Recommendation Report for Planning Permission for Works or Extension to a Dwelling

REF NO: M/91/20/HH

LOCATION: 166 Elmer Road
Middleton-On-Sea
PO22 6JA

PROPOSAL: Single storey rear extension with terrace above including demolition of existing conservatory, enlargement of window to west elevation & replacement cladding.

REV	DRAWN	DATE	DESCRIPTION
CLIENT			
Mr & Mrs Ashbery			
SITE ADDRESS			
166 Elmer Road Elmer West Sussex PO22 6JA			
DRAWING TITLE			
Proposed Extension Proposed Plans Proposed Elevations			
SCALE			
As Shown			
DATE			
October 2020			
REFERENCE			
166 Elmer Road			
DRAWING No.		REV.	
002

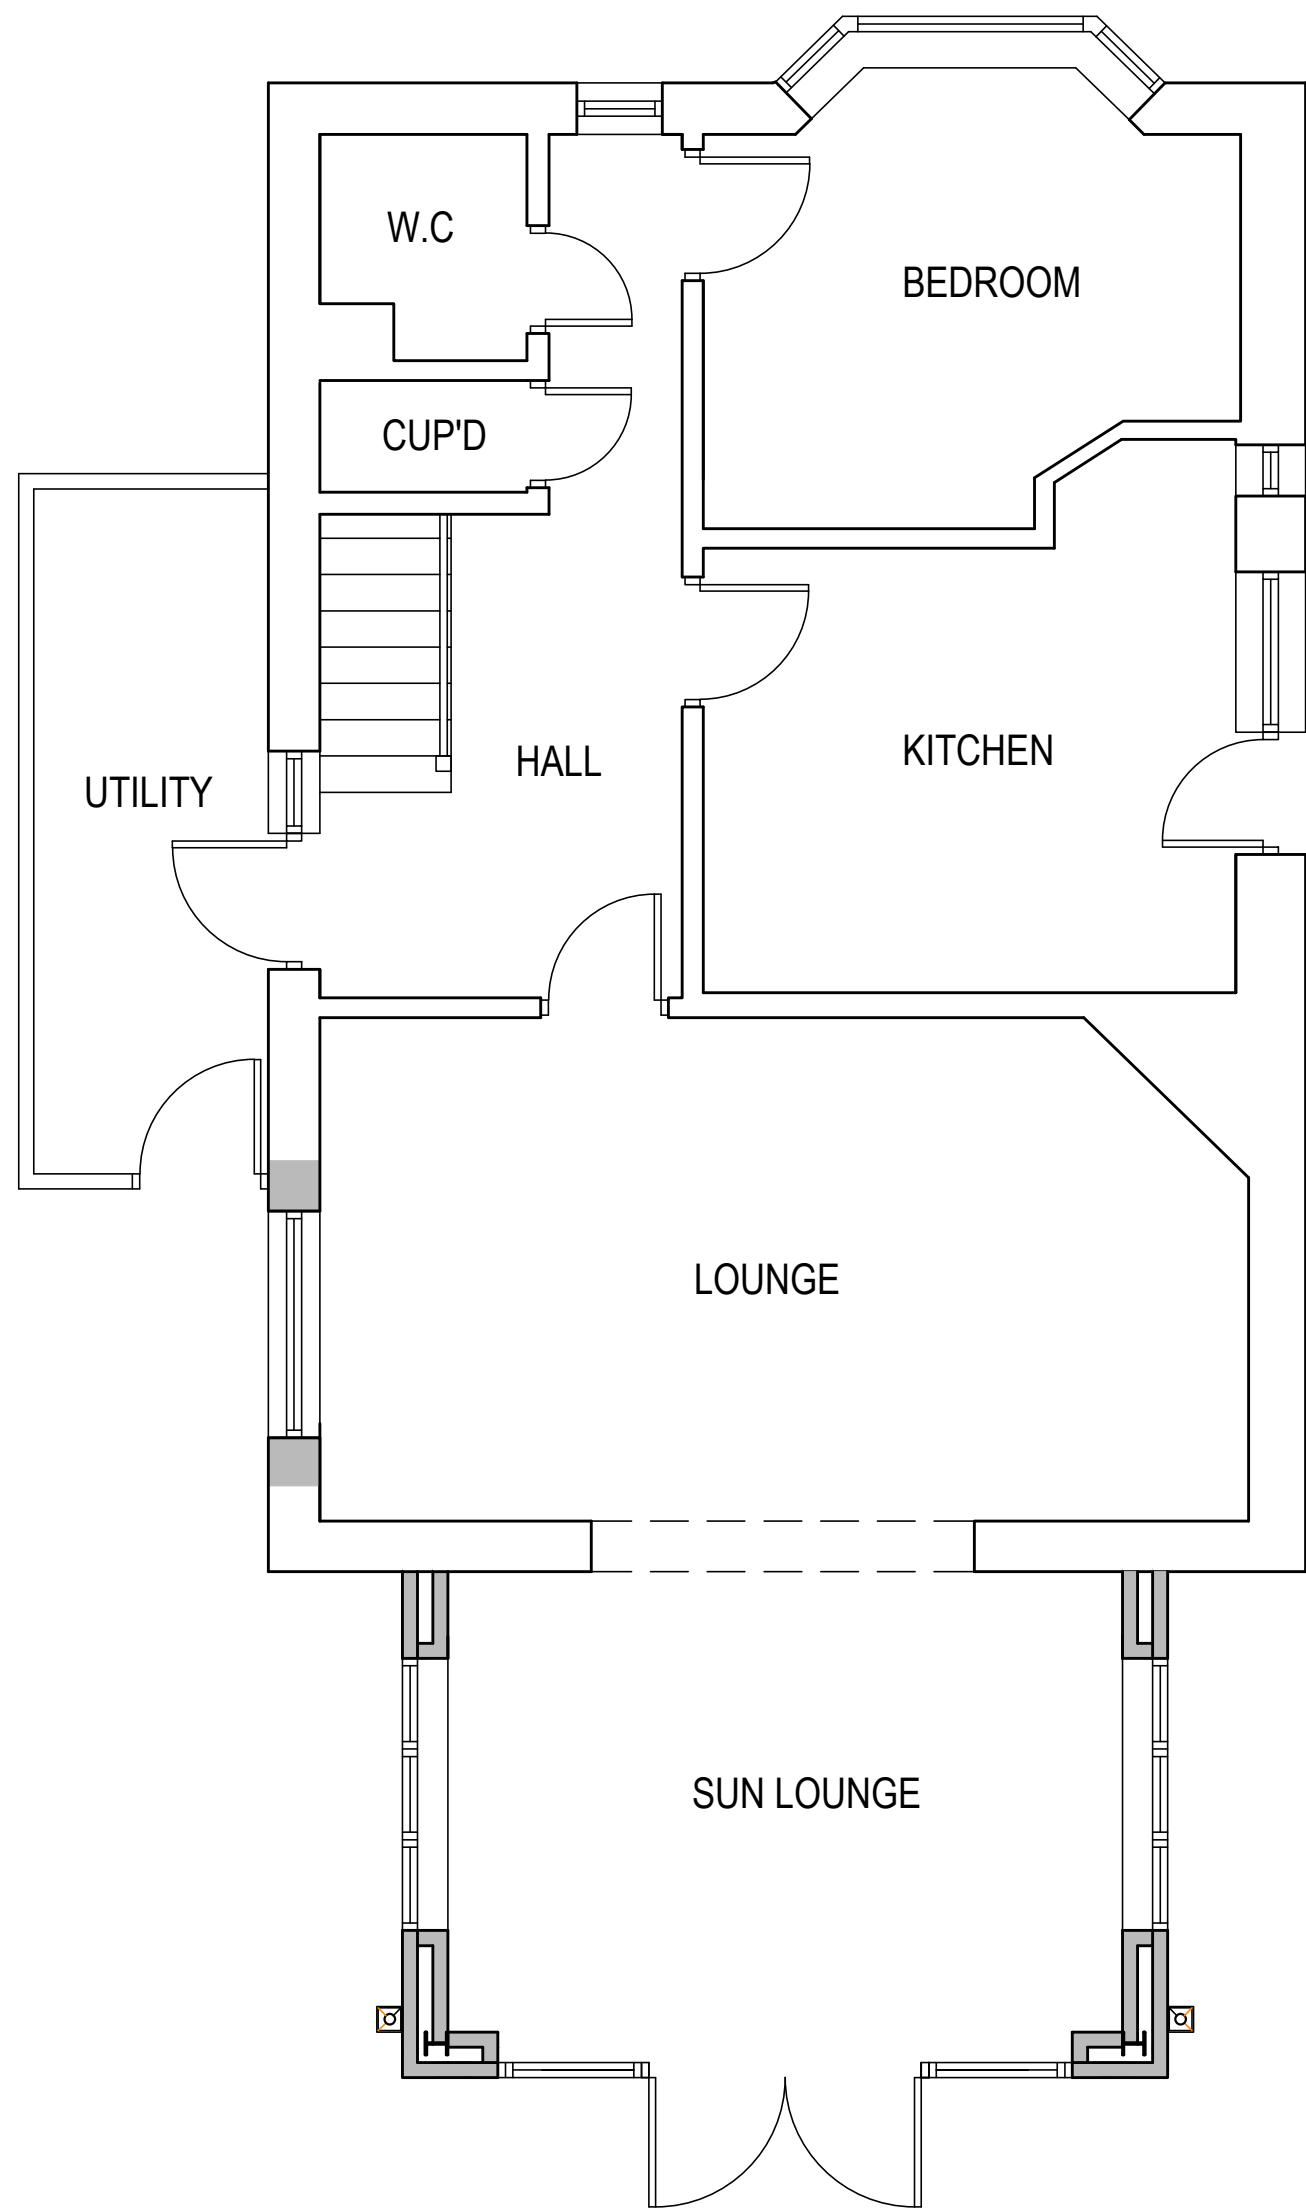
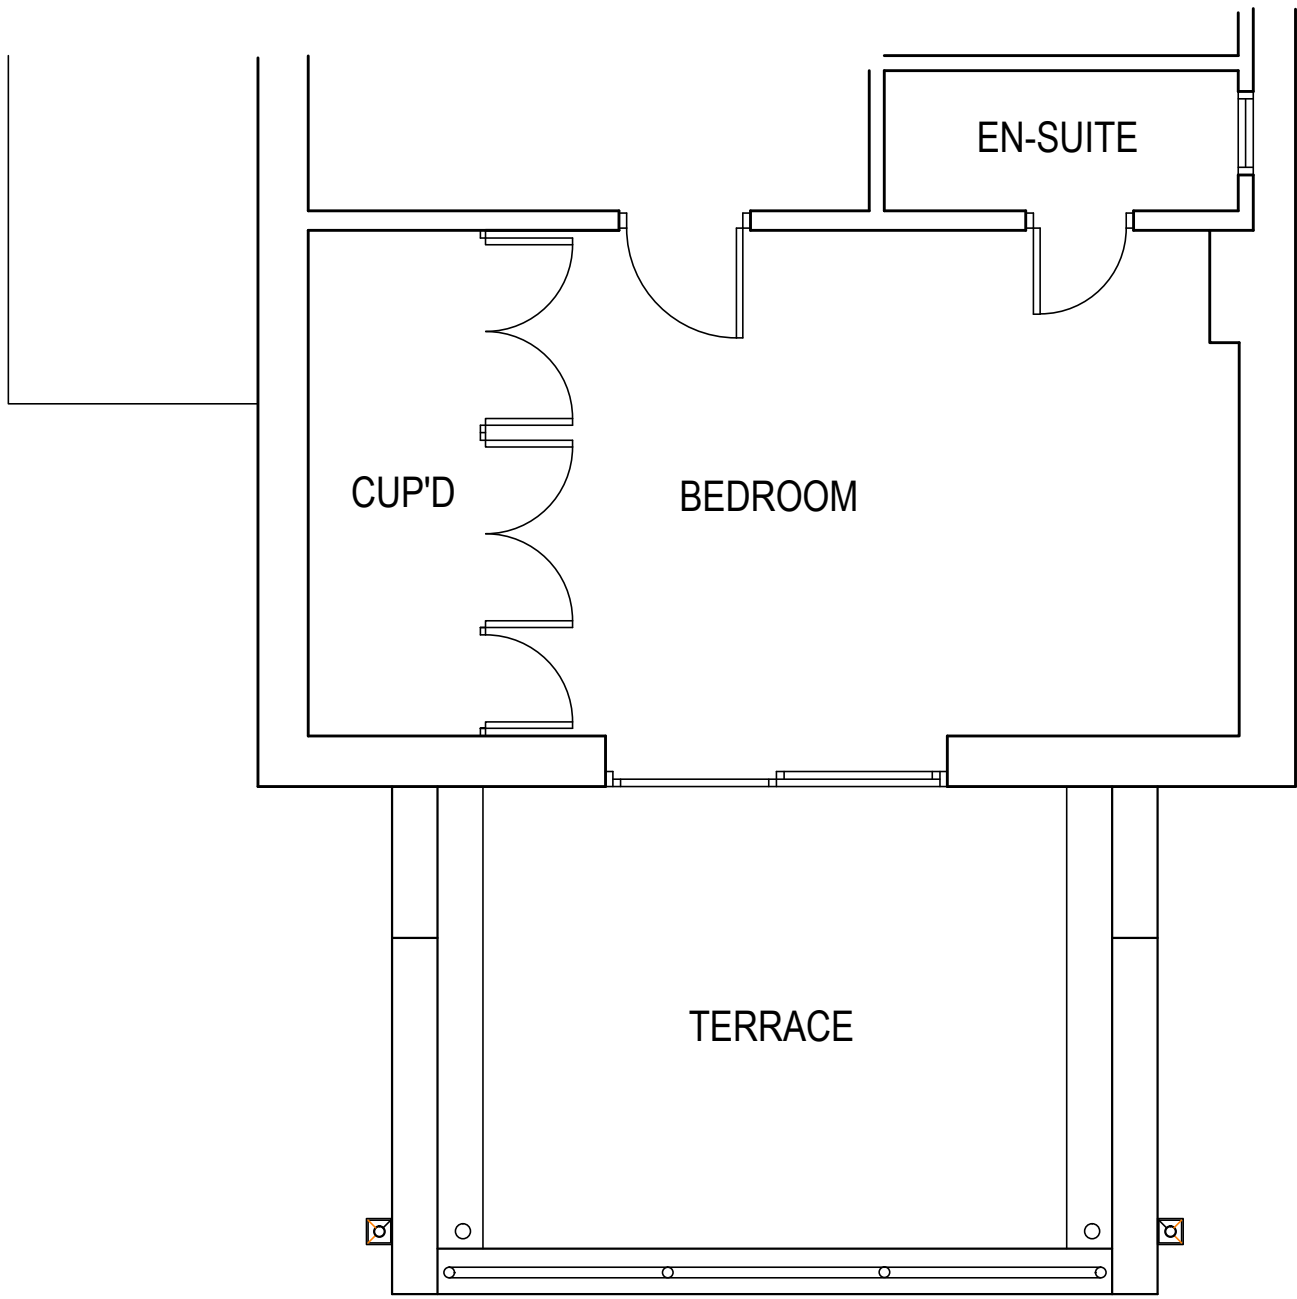
The proposed balcony has screening to the east and west at two heights, the majority being approximately 1.3m which will allow for some views of the neighbouring rear amenity space. Due to the location with the beach to the rear of the properties long views from the balcony will be towards the sea and the application sites rear garden. However, views towards the neighbouring properties gardens can be gained from the side of the balcony and to avoid these harmful views a condition will be imposed requiring screening to a height of 1.7m be erected.

- 3 Solid/obscured balcony screening shall be constructed to a height of 1.7m to the east and western elevation of the proposed balcony to the rear of the property. The screening shall be installed prior to the first use of the balcony and be retained thereafter in perpetuity.
